Appeal Decision

Appeal Ref: APP/T2350/A/12/2188270

Land to the rear of Hazlemere, Pimlico Road, Clitheroe BB7 2AG

- The appeal is made under section 78 of the Town and Country Planning Act 1990 against a refusal to grant planning permission.
 - The appeal is made by Sunderland Peacock and Associates against the decision of Ribbles Valley Borough Council.
 - The application Ref 3/2011/0991, dated 22 November 2011, was refused by notice dated 25 May 2012.
 - The development proposed is erection of three dwellings with associated vehicular access and landscaping.
-

Drawing Title
Proposed Site Plan

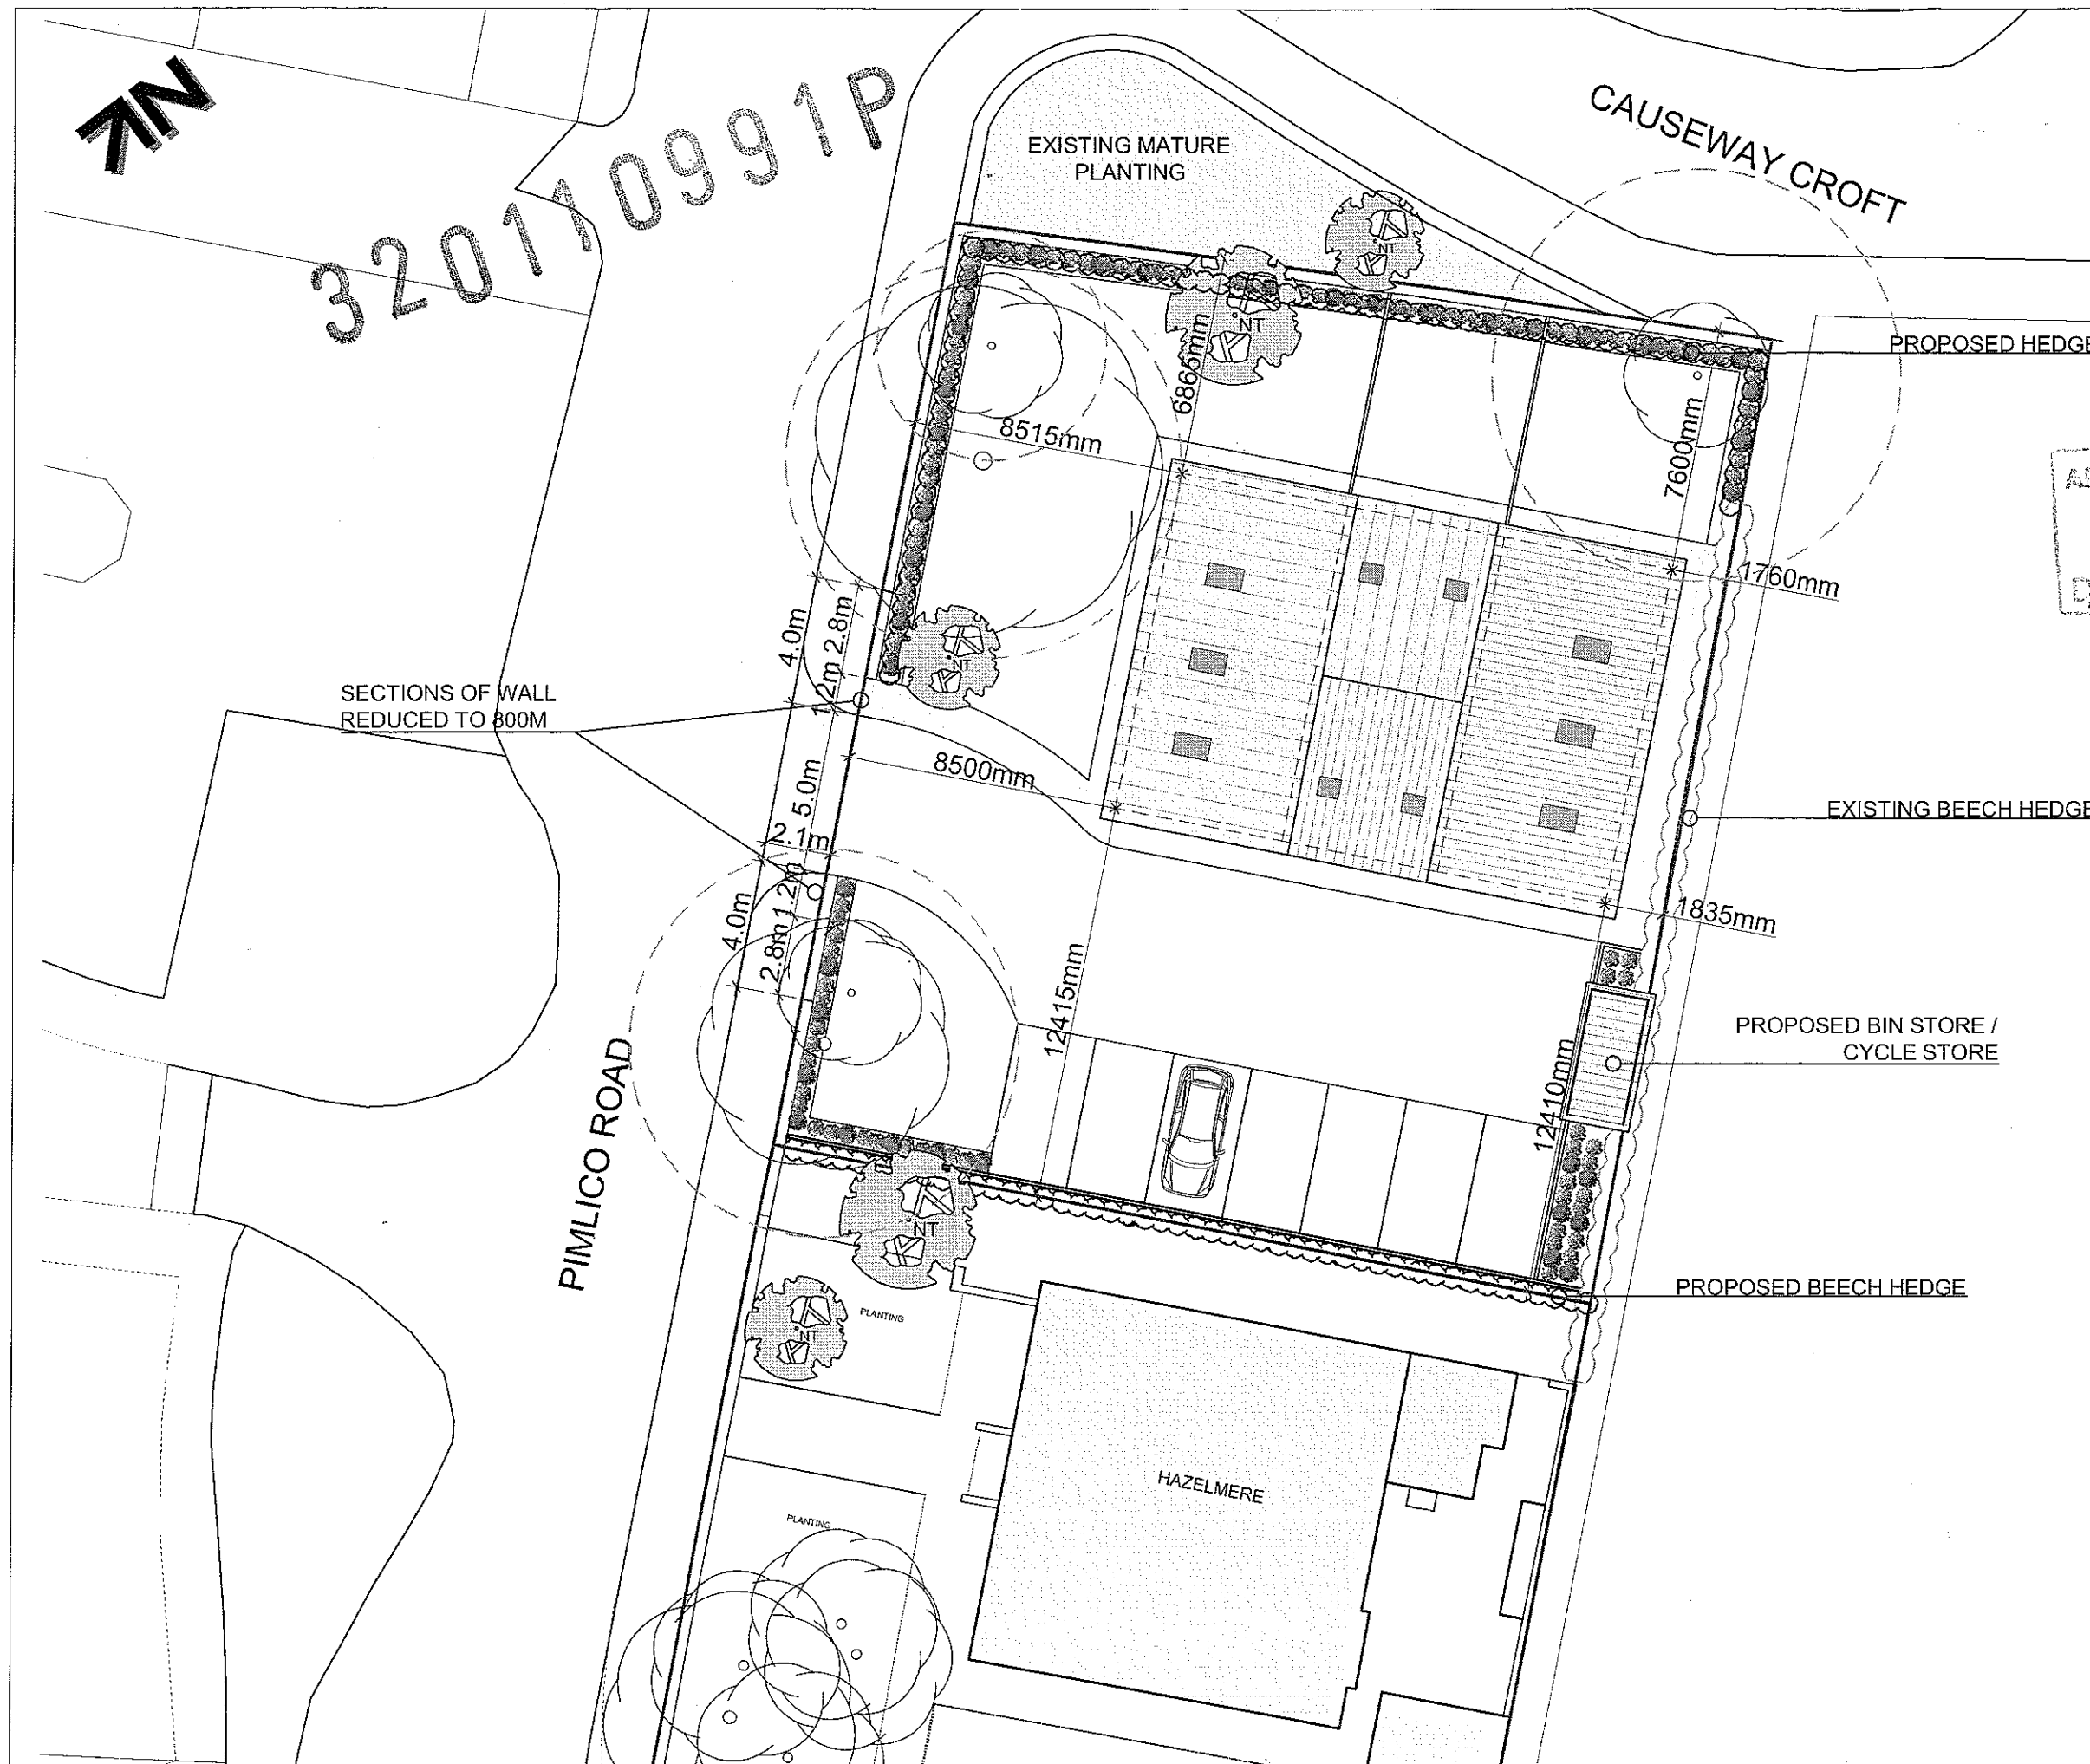
8. The site is about 780 square metres, the proposed building would have a footprint of about 165 square metres, and hard landscaping would cover about 290 square metres. Only about 325 square metres of the site, about 42%, would remain soft landscaped. The proposed development would result in a significant loss of 'green space' visible from, and alongside, a main road in the town. Furthermore, apart from small areas of vegetation to the east of Hazlemere this building would be in a wholly hard landscaped plot. There would be only a hedge between a path on the north side of the building and the proposed parking area and this would be the only vegetation between the existing and proposed buildings.

11. Other aspects of the design of the building are poorly conceived. First floor balconies to kitchen/dining rooms would be on the north side of the building and thus in shade for all but a few hours in the early morning and late evening during summer months. The rear garden of the middle dwelling would only be accessible through a ground floor bedroom. It was noted at the site visit that the east elevation of the building would be touching the beech hedge along the east boundary. Either there is no space for the metre wide pathway shown on the proposed site plan or a section of the hedge would have to be removed. A section of existing hedge would have to be removed to site a proposed cycle/bin store.

Drawing Title
Proposed Elevations

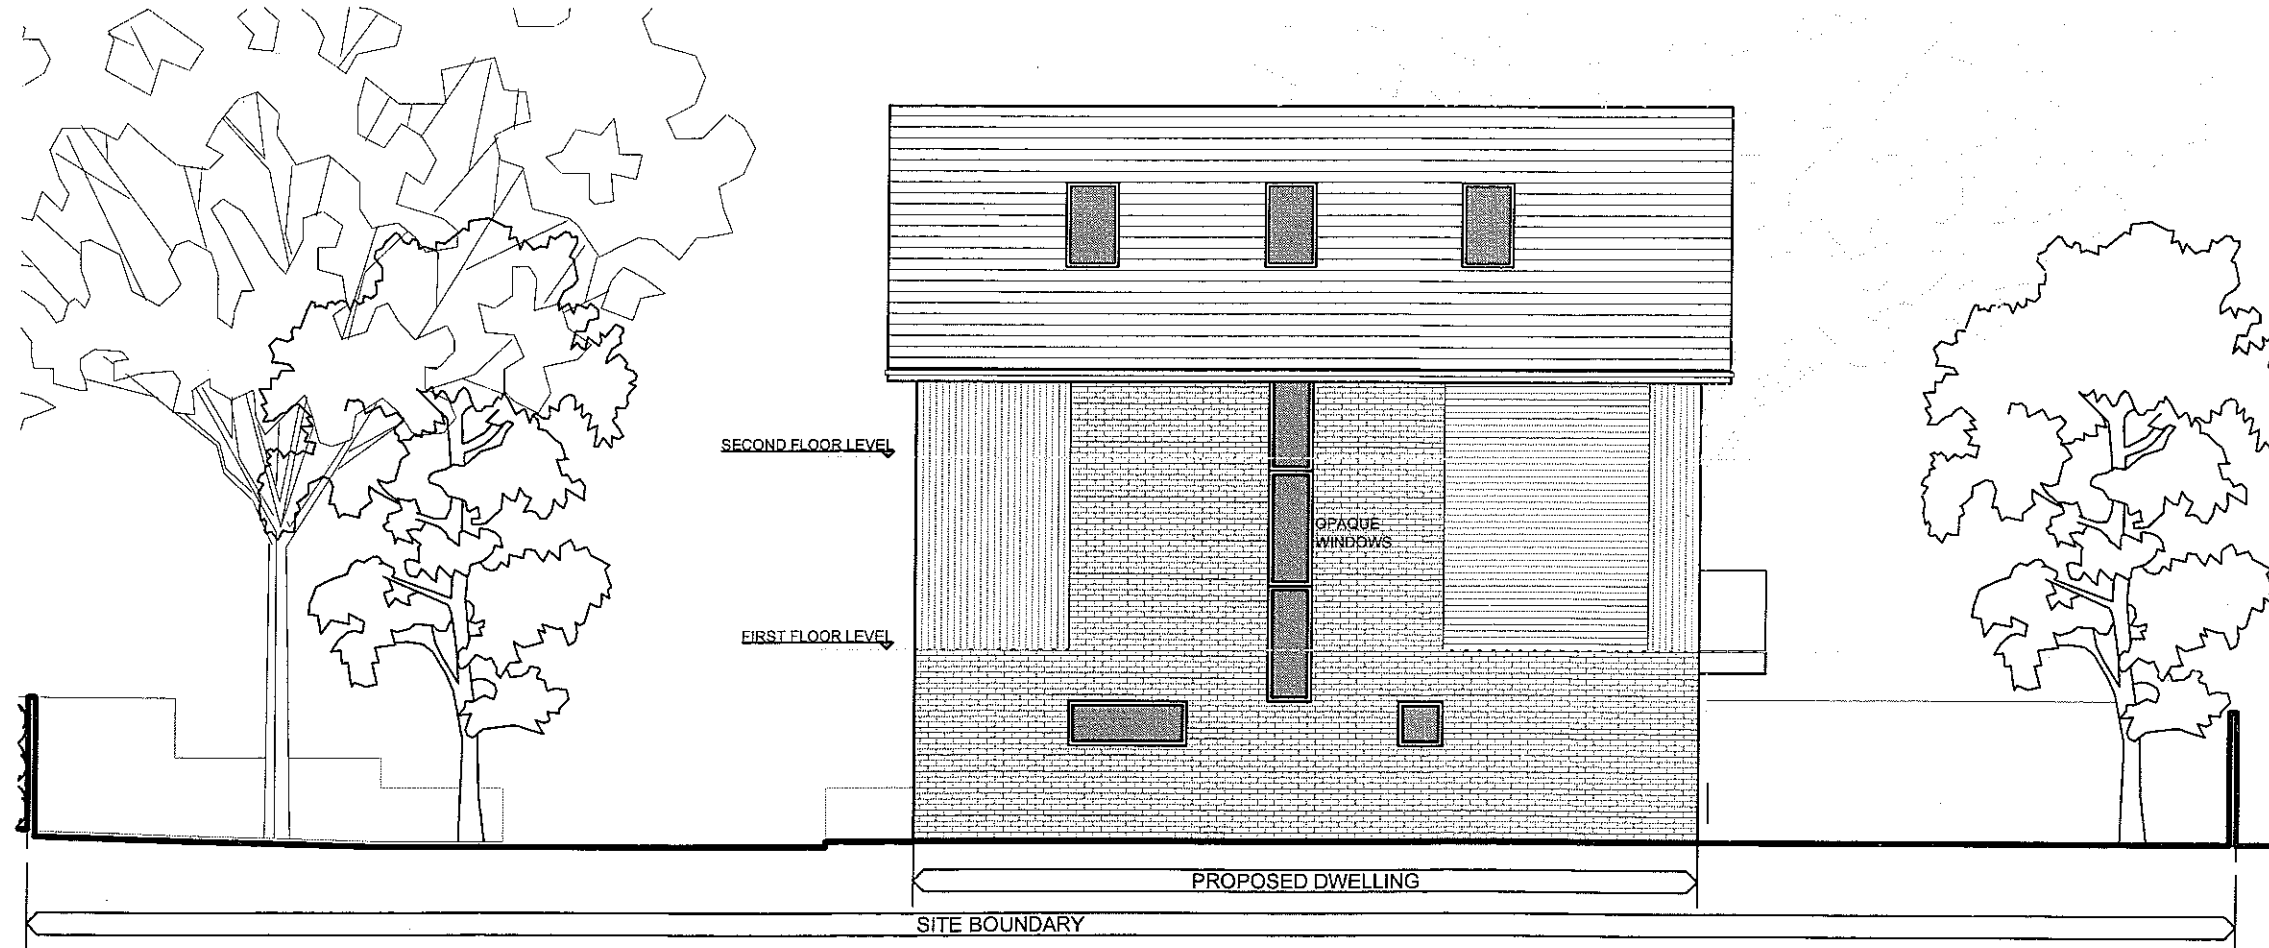
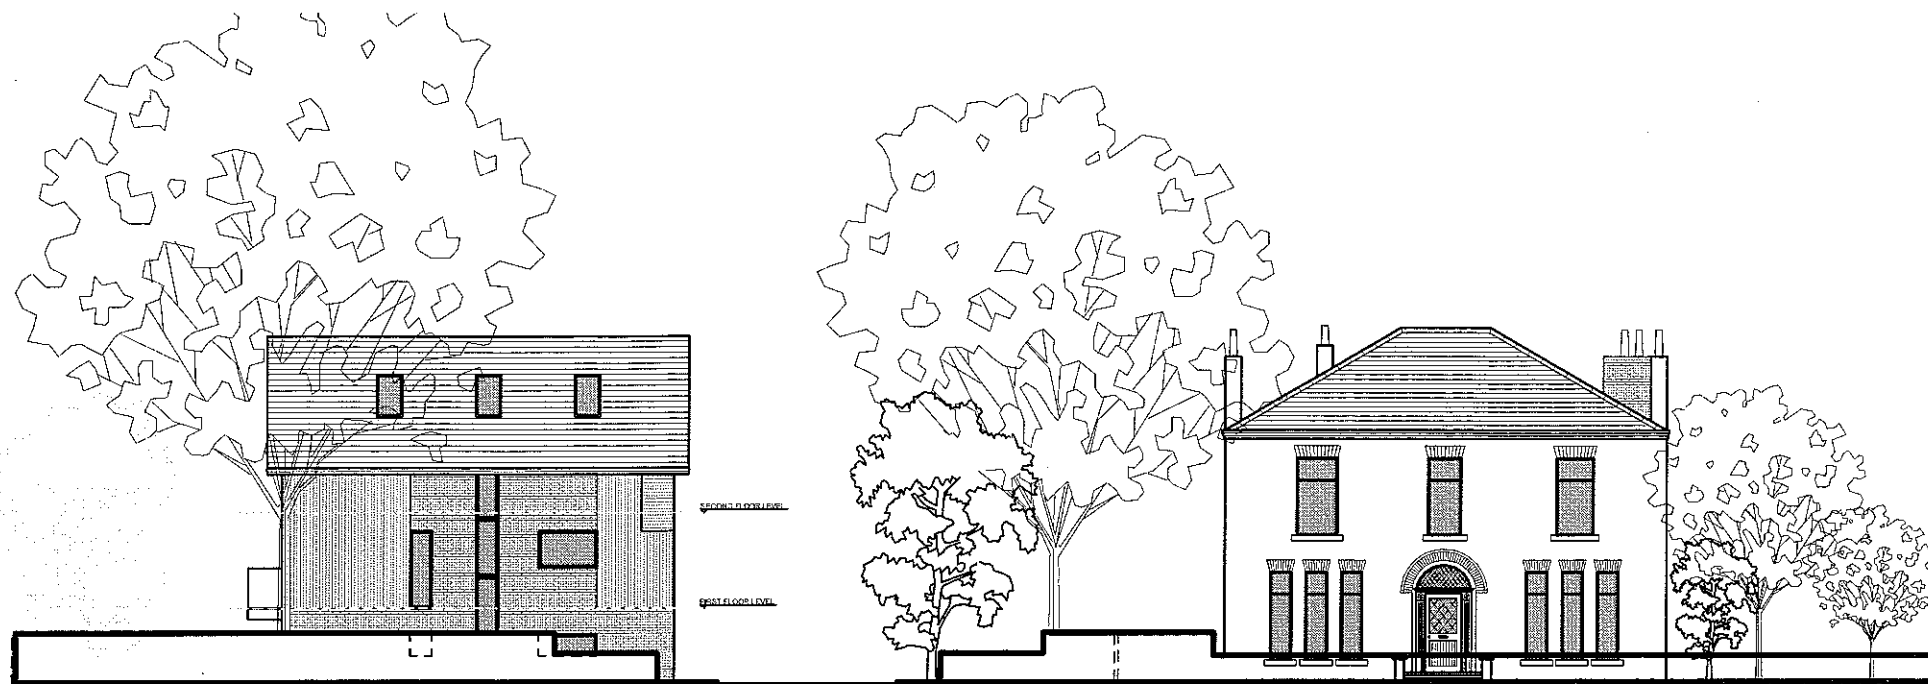
9. Of greatest concern, however, is the design and scale of the proposed building. Its west elevation to Pimlico Road would be about one metre wider than the frontage of Hazlemere and, though the ridge of its roof would be no higher than that of the existing building, the roof would be a monopitch rather than the hipped roof of Hazlemere. Consequently, the proposed building, given also its greater depth, would have a greater presence in the streetscene than Hazlemere, which would therefore lose some of its townscape merit. The form and scale of the monopitch roof would be inappropriate in an area where roof planes are seldom dominant features of buildings.

10. The monopitch roof would be repeated on the east side of the proposed building and the central dwelling would have a gable roof with an east-west ridge. This juxtaposition of roof planes and forms would be a confusing feature of the building. Confused is also a criticism that can be aimed at the proposed windows of the building. Windows would be of random sizes and proportions and would be randomly located on the building's elevations. The fenestration lacks cohesion. This lack of cohesion in the design of the building would be exacerbated by the mainly timber boarded upper floors of the building being randomly divided into sections of vertical and horizontal boarding.
